**KIRKLEES METROPOLITAN COUNCIL
INVESTMENT & REGENERATION SERVICE**

DELEGATED DECISION TO DETERMINE PLANNING APPLICATIONS

Reference No:	2026/62/90636/E
Site Address:	30, Mallard Close, Heckmondwike, WF16 0NE
Description:	Erection of two storey rear extension and side dormer window and raising height of roof and eaves to form second floor
Recommending Officer:	Jennifer Booth

DECISION - REFUSED

PROPOSED SIDE ELEVATION
(South East)

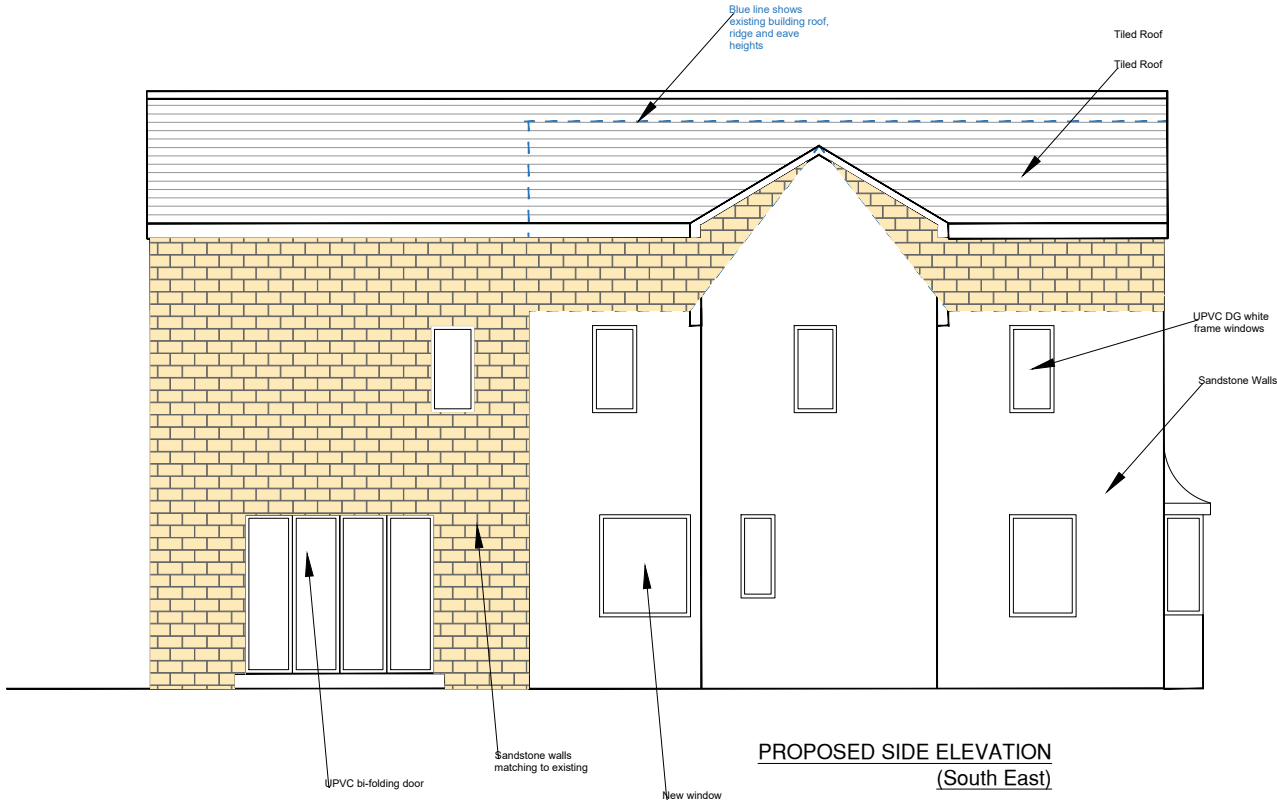
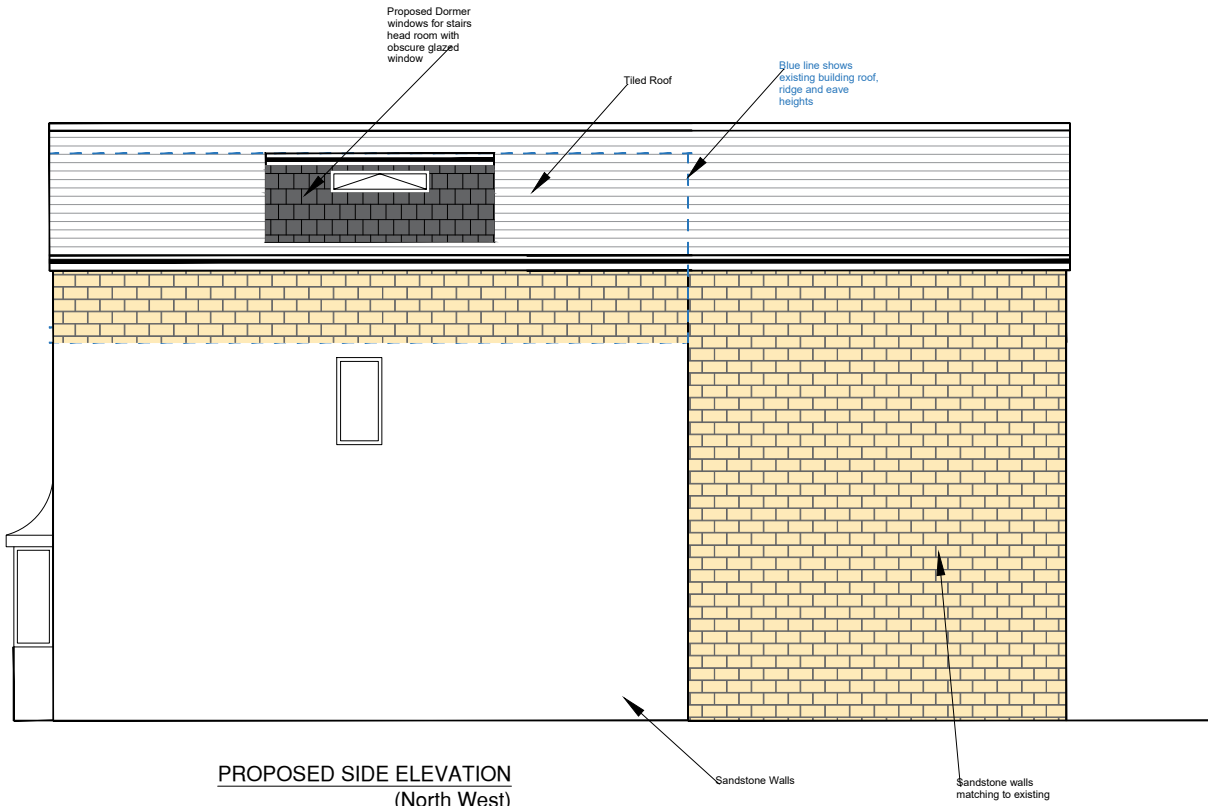
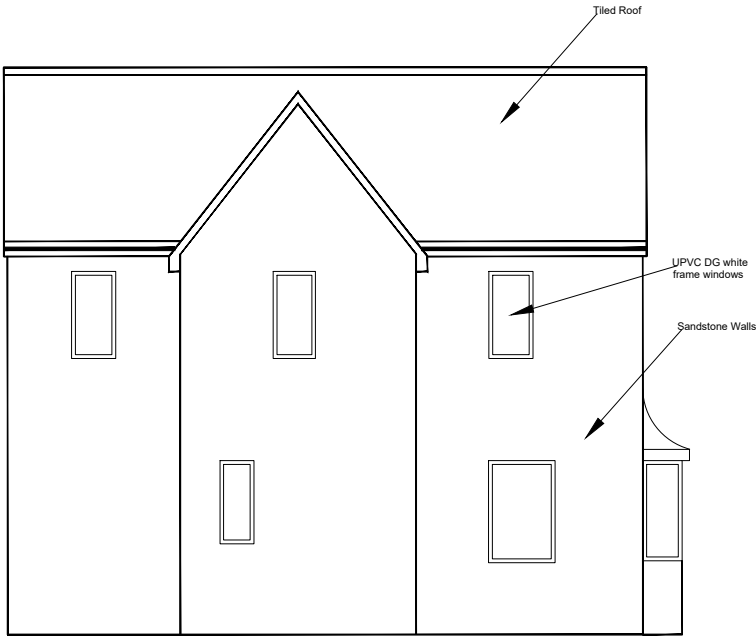
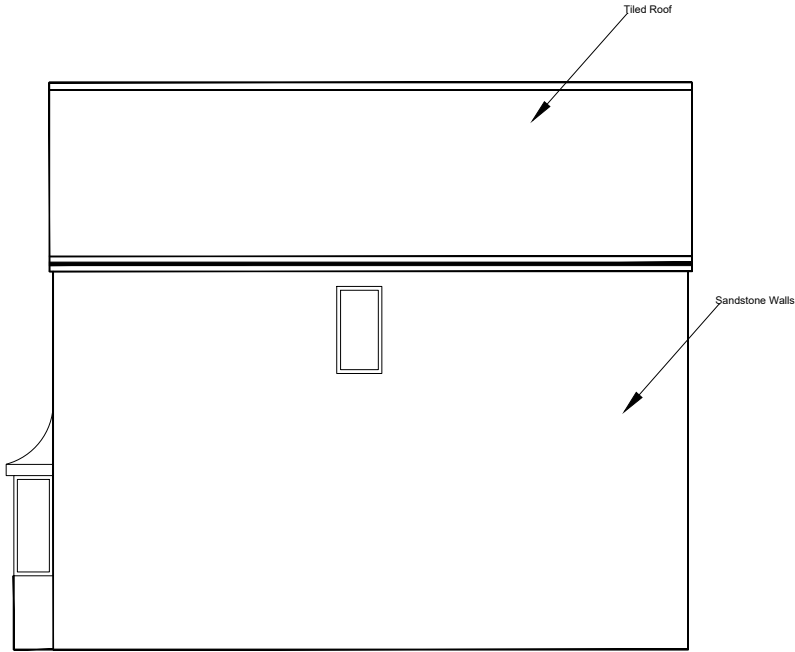
The eaves height of the dwelling would be increased by 0.9m with an increase to the apex of 0.4m.

With regard to visual amenity, the proposal includes an increase in both the eaves height and overall ridge height of the dwelling, alongside the insertion of a dormer. As a result, the amended dwelling would exceed the height of neighbouring properties within the same row of two-storey dwellings constructed at a similar time. Although it is appreciated that the increase in overall height is only 0.4m, the design results in a development that would be out of keeping with its neighbours. The dwelling forms a 'book end' to this small development, mirroring the scale and design of the property at the opposite end of the row. Whilst it is noted that the streetscene to the south east changes to three-storey townhouses which are differing building line, materials and design and therefore read as a separate character and architectural style. Consequently, the increase in height at the host property would not serve to visually link the two forms of development and would instead appear as an incongruous addition, disrupting the established character of the existing row. Notwithstanding this, the dormer itself is modest in scale, discreetly positioned, and would result in only limited visual impact within the wider streetscene.

When considered cumulatively, the proposed raising of the roof to increase both the eaves and overall ridge height, together with the substantial 5-metre rear extension, would result in a form of development that is not subordinate to the host dwelling. The combined scale of the works would significantly alter the original proportions and appearance of the property, such that it would no longer read as a modestly extended dwelling. The increase in height would cause the property to appear overly prominent within the existing row, while the depth and scale of the rear extension would represent an excessive level of development within a restricted plot, effectively overdeveloping the rear garden space. Taken together, the proposal would create a

visually awkward and unbalanced form, failing to respect the scale, proportions, and character of the host dwelling and resulting in an unacceptable cumulative impact on visual amenity.

PROPOSED GROUND FLOOR PLAN

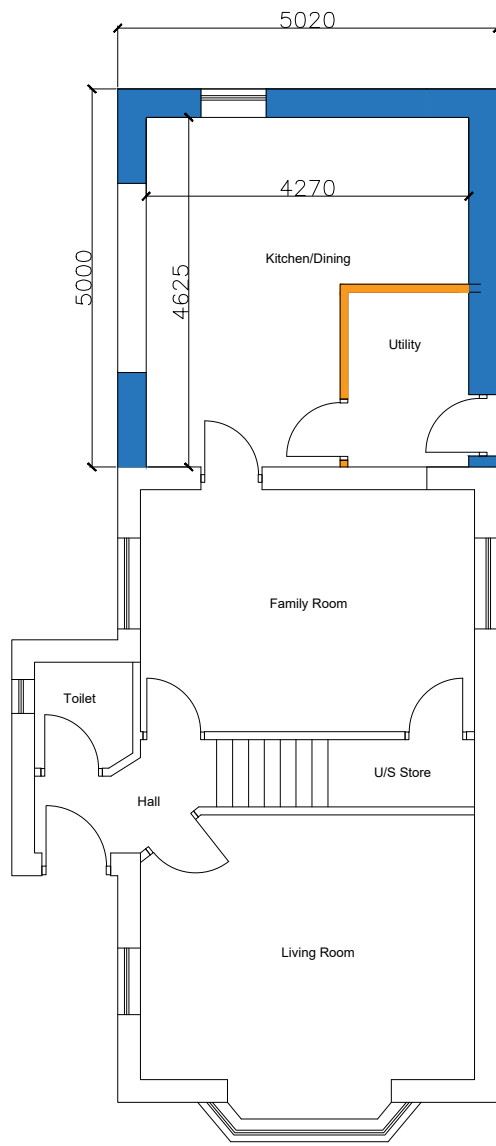
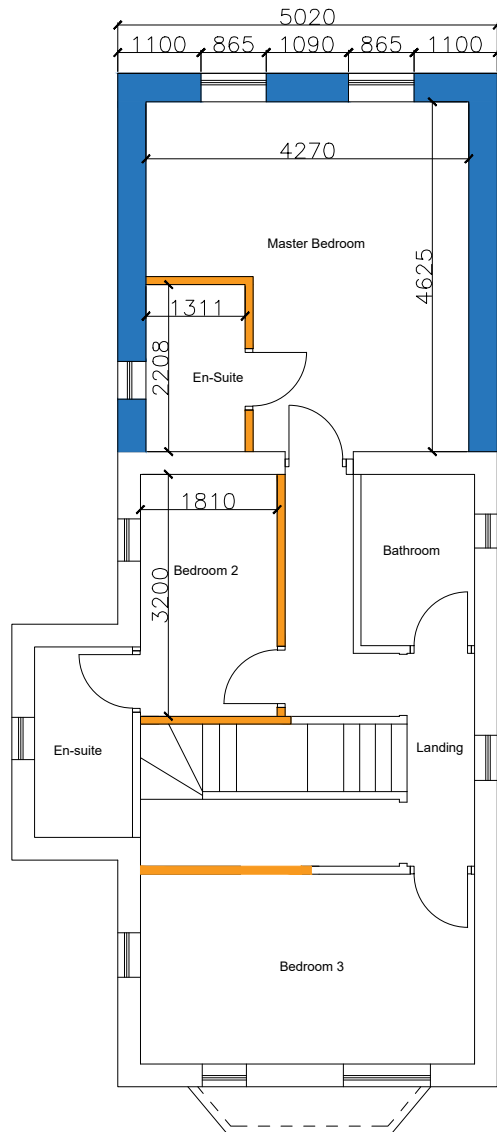
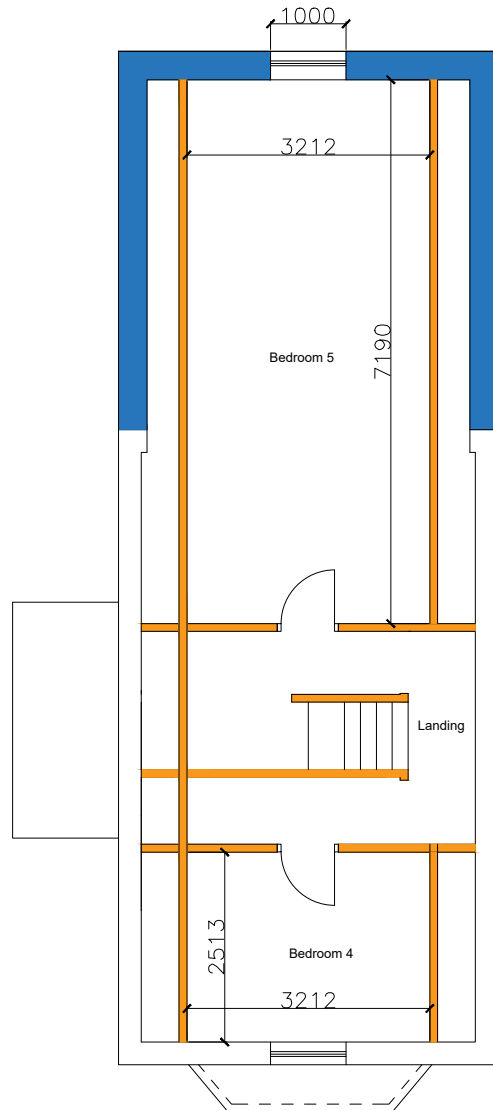
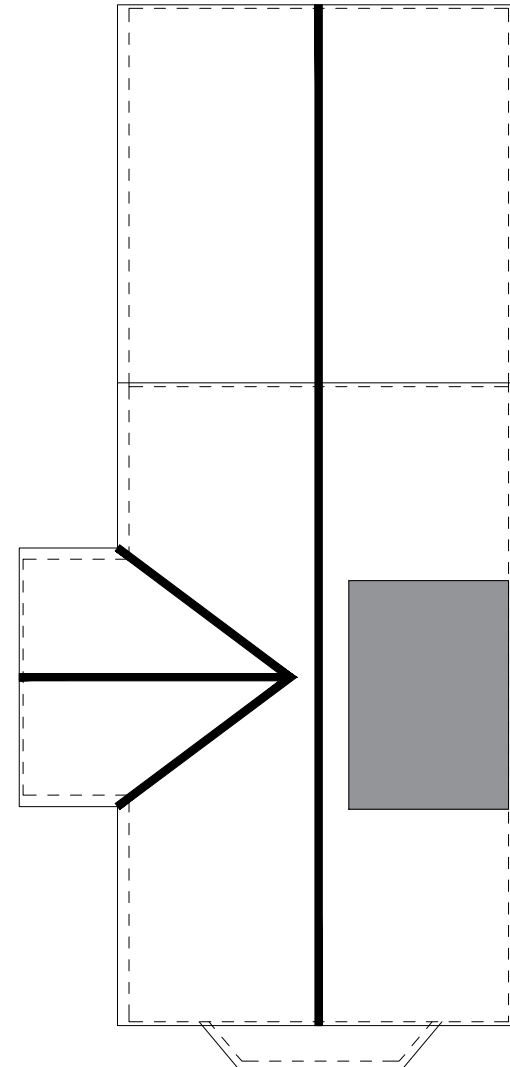
The proposed rear extension would project approximately 5 metres from the rear elevation. Given that the existing garden measures only around 7 metres in depth and 7.45 metres in width, the extension would occupy the substantial majority of the available rear amenity space. As such, the proposal would represent an unacceptable scale of built form within the plot, resulting in an overdevelopment of the rear garden area and failing to maintain a suitable balance between built development and private external space which would be out of character with the house and surrounding properties. The height and depth of the extension would appear excessive in this constrained context, leading to a visually dominating rear elevation. Furthermore, the increased roof height in combination with the form of the extension and the arrangement of openings would significantly alter the proportions of the host dwelling, resulting in a visually awkward and ungainly appearance that would detract from the character and visual amenity of the property. Although it is noted that the materials proposed would be to match the main house, the overall scale and appearance is unacceptable in terms of visual amenity.

1. The proposed 5-metre rear extension would project into a rear garden of only approximately 7 metres in depth, occupying the majority of the available private amenity space. In this constrained context, the scale and bulk of the extension would represent an excessive and dominant form of development, resulting in the overdevelopment of the rear of the plot. The extension would fail to respect the original proportions of the host dwelling and would detract from its visual appearance. To permit the proposals would be contrary to Policy LP24 of the Kirklees Local Plan, KDP1 & KDP2 of the House Extensions & Alterations SPD and Chapter 12 of the National Planning Policy Framework.

PROPOSED FRONT ELEVATION
(North East)

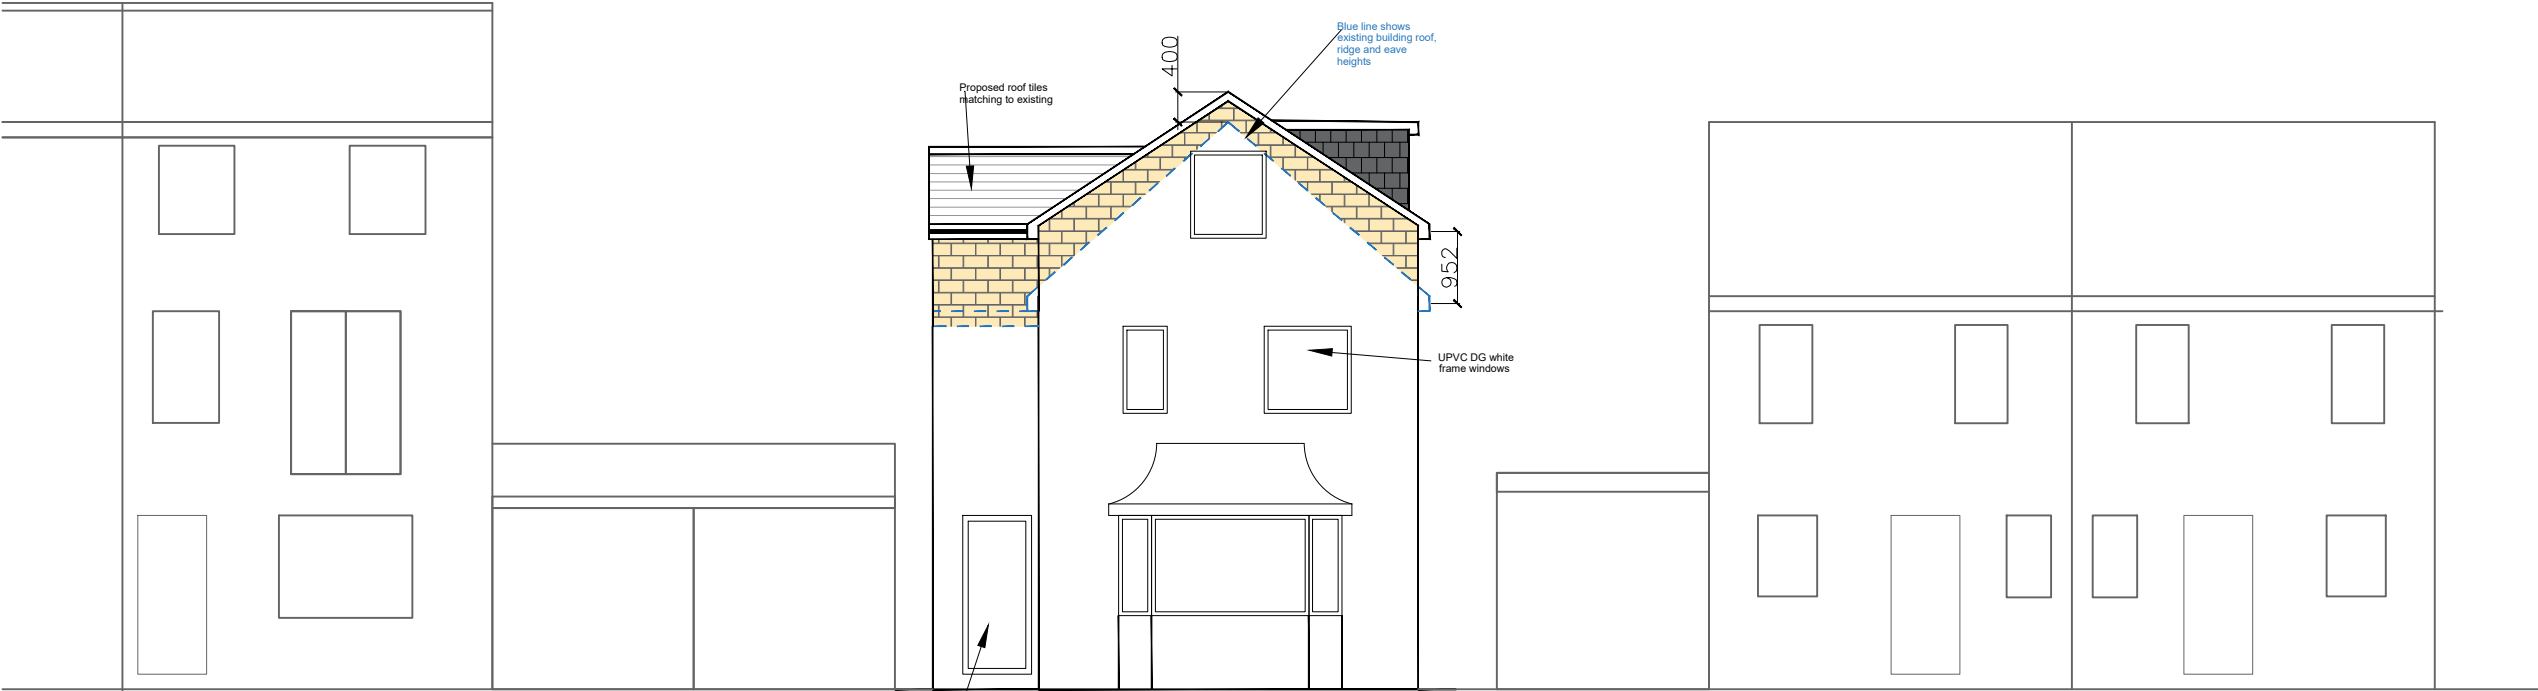
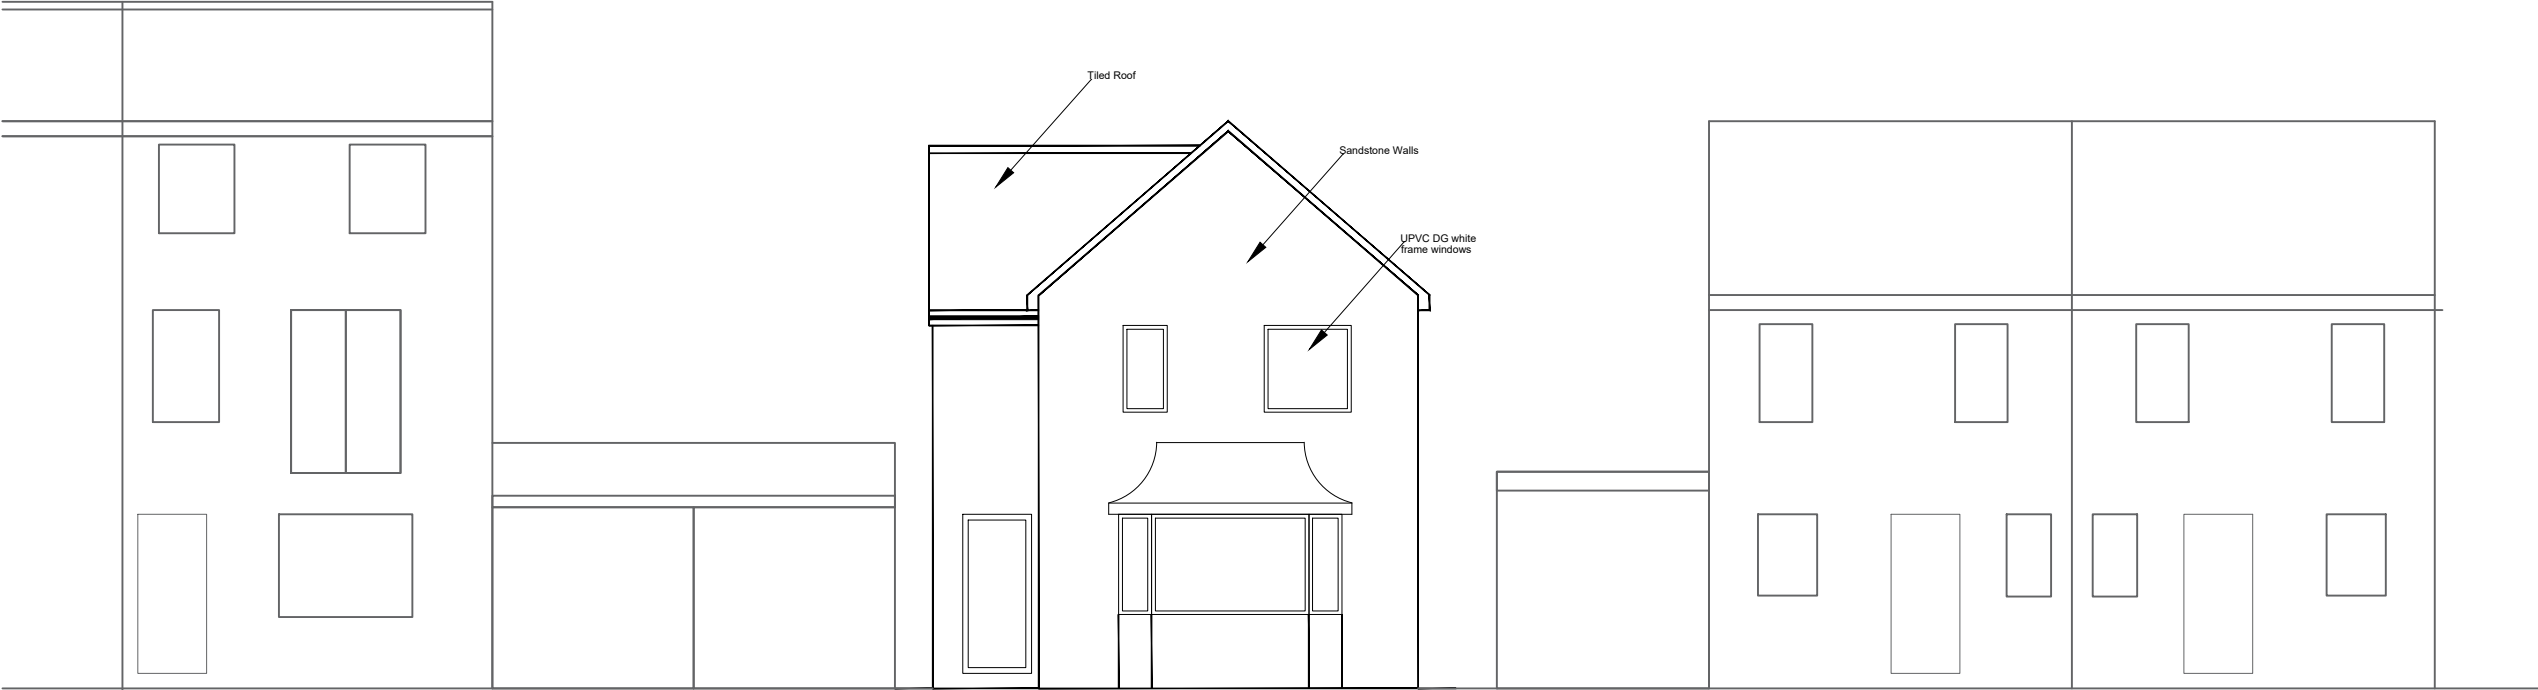
1. The proposed development due to the increase in eaves and ridge height would result in the dwelling exceeding the height of neighbouring properties within the established row of two-storey dwellings to the detriment of the streetscene. The increased height would appear visually incongruous, disrupting the uniform scale and character of the row and resulting in harm to visual amenity. To permit the proposals would be contrary to Policy LP24 of the Kirklees Local Plan, KDP1 & KDP2 of the House Extensions & Alterations SPD and Chapter 12 of the National Planning Policy Framework.
